(RR-037) ELAF: Proposed permissive paths & north-south greenway – confirm WCH – not just cycleway
Deadline 8: Wednesday 18 January 2023

Mrs Katherine Evans
Chairman – Essex Local Access Forum
18 January 2023

7.14(a)

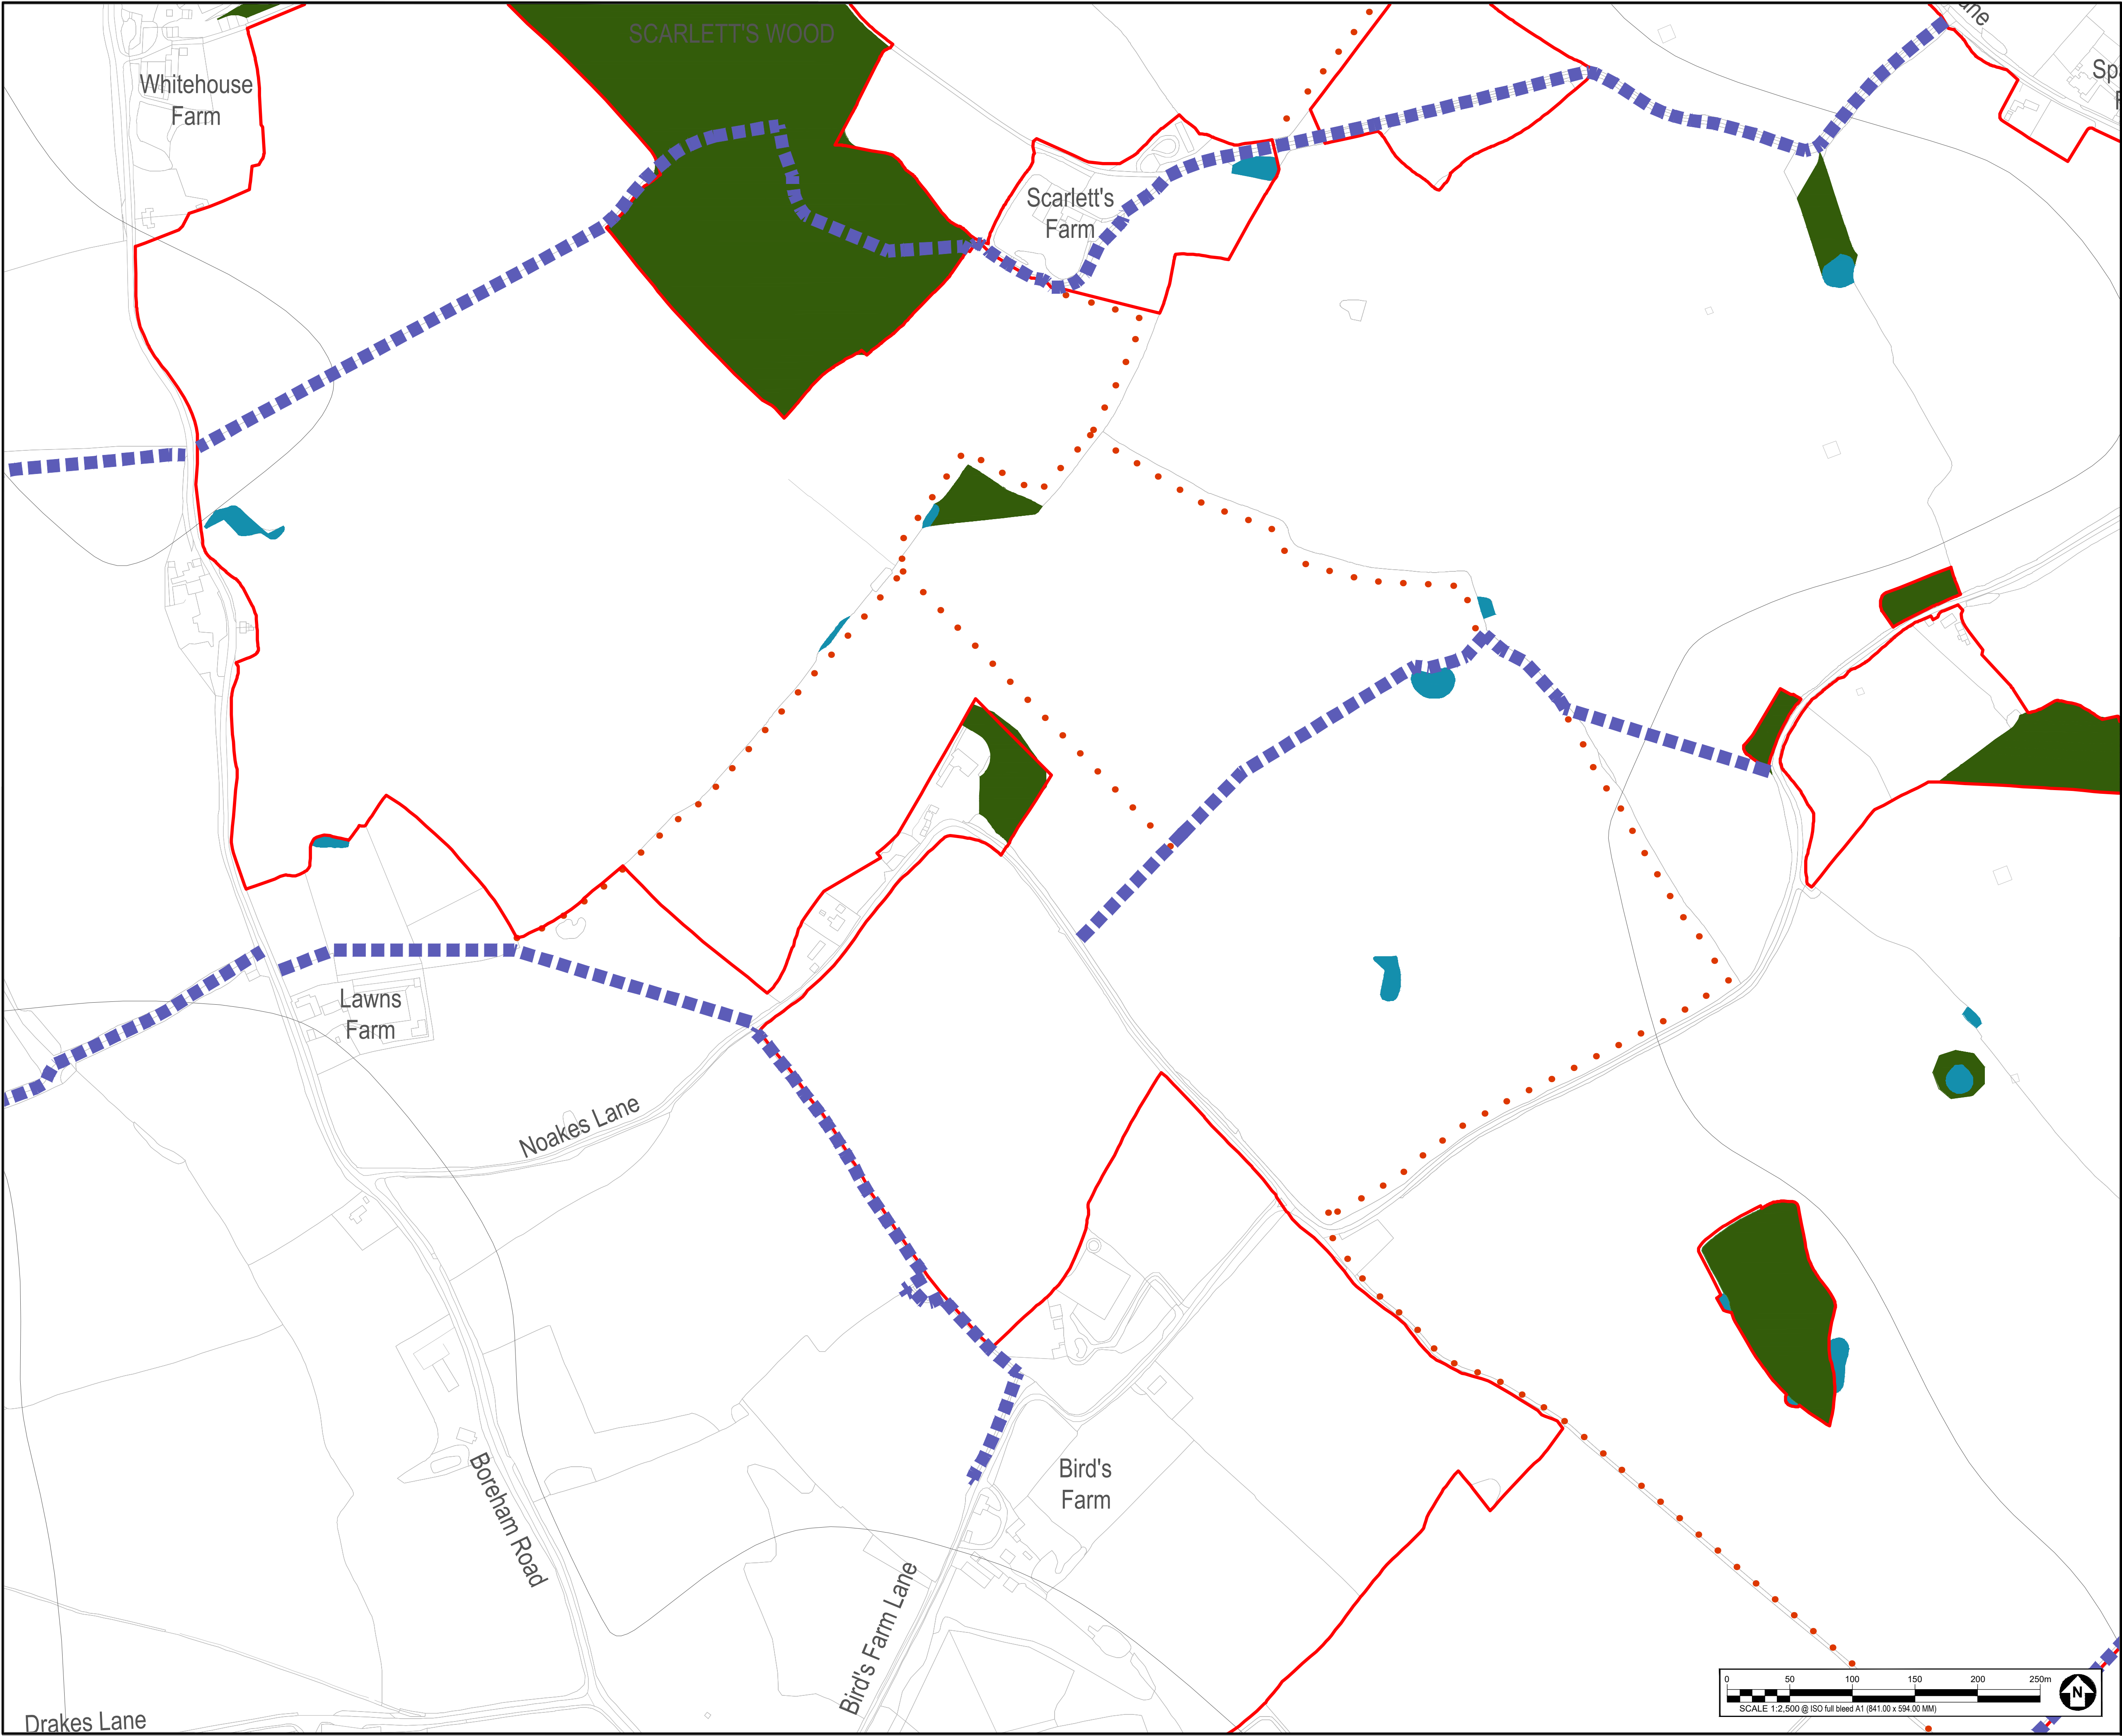
- 1) In keeping with ELAF's "access for all" objectives, ELAF are pleased to see the extra permissive path connection along the northern side solar field PDA7 shown on Sheet A of the revised 7.14 Permissive Paths Plan [REP7-018]. This will provide an inclusive connection for walkers, cyclists and horse-riders from the permissive path network to Sparrows Farm Lane (Rolls Farm Lane), a public vehicular road.
